BR/10/20/PL

8A Sadler Street Bognor Regis PO21 1UA

Replacement of 2 No. timber windows, 1 No. timber bay window & 1 No. timber door all with PVCu windows (only bedroom window will be sliding sash) & door

Title
Floor Plans

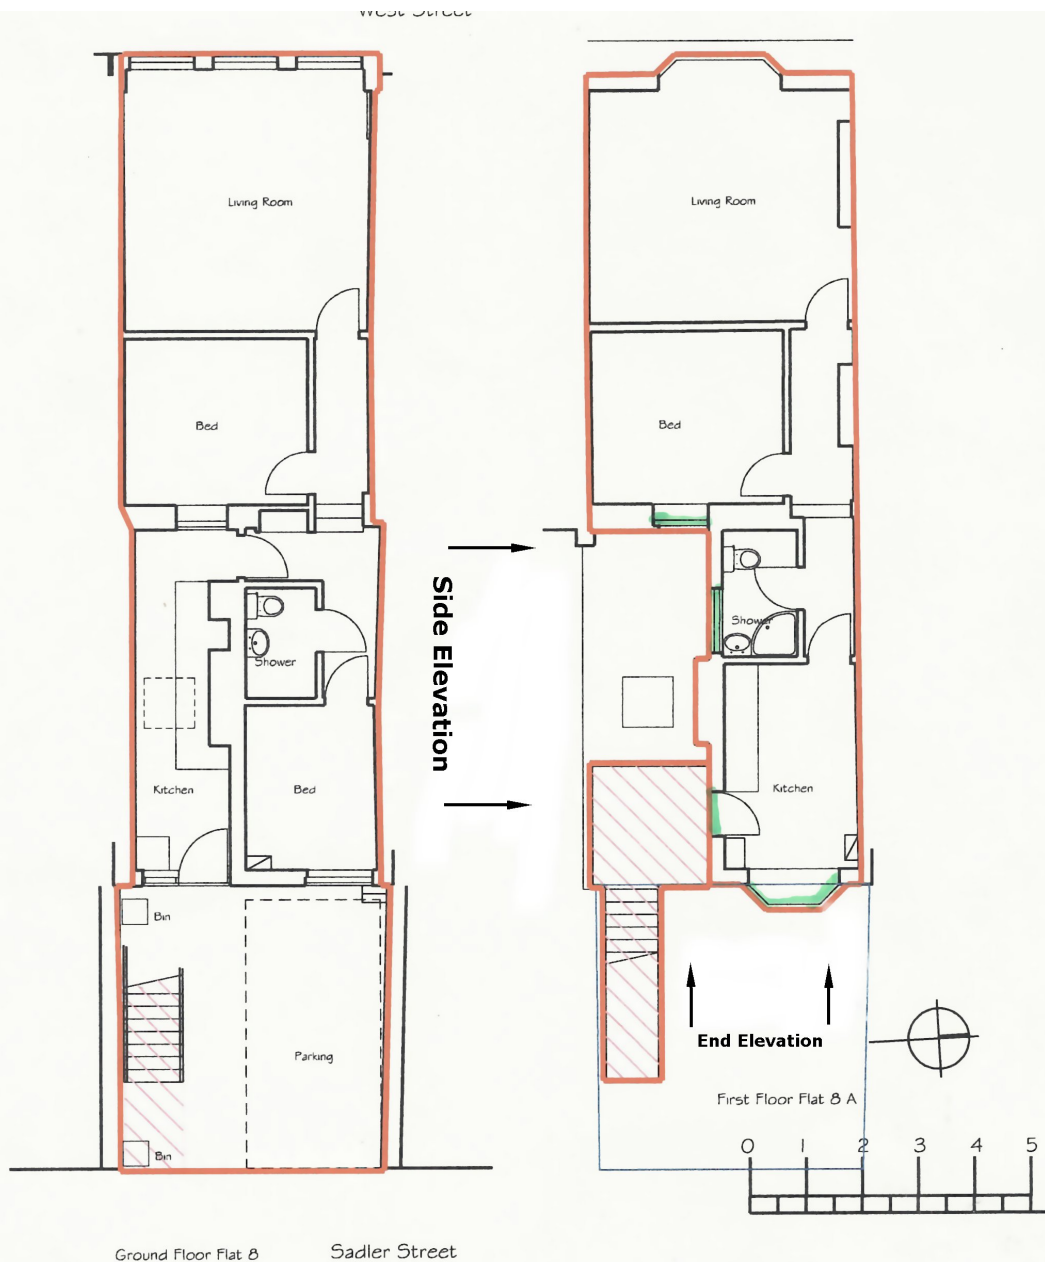
The proposal is to replace the existing traditional windows with UPVC ones. Windows are an important feature within a building, and their replacement should be carefully considered. It is considered that this proposal is problematic; the design, detailing and operation of windows constructed from UPVC make them appear different to

Normally within Conservation Areas we try to support the use of traditional materials, such as wood, as this respects the character of the area and the buildings within them. This is especially true of those windows which face on to the public realm. As a consequence, any new windows should reflect the appearance/materials of those currently installed in the building.

Whilst an explanation has been provided as part of the application, it is not considered that it adequately justifies why the existing windows cannot be replaced on a like for like basis. As a consequence, my preferred approach would be to use traditional materials to the public facing elevations of the property.
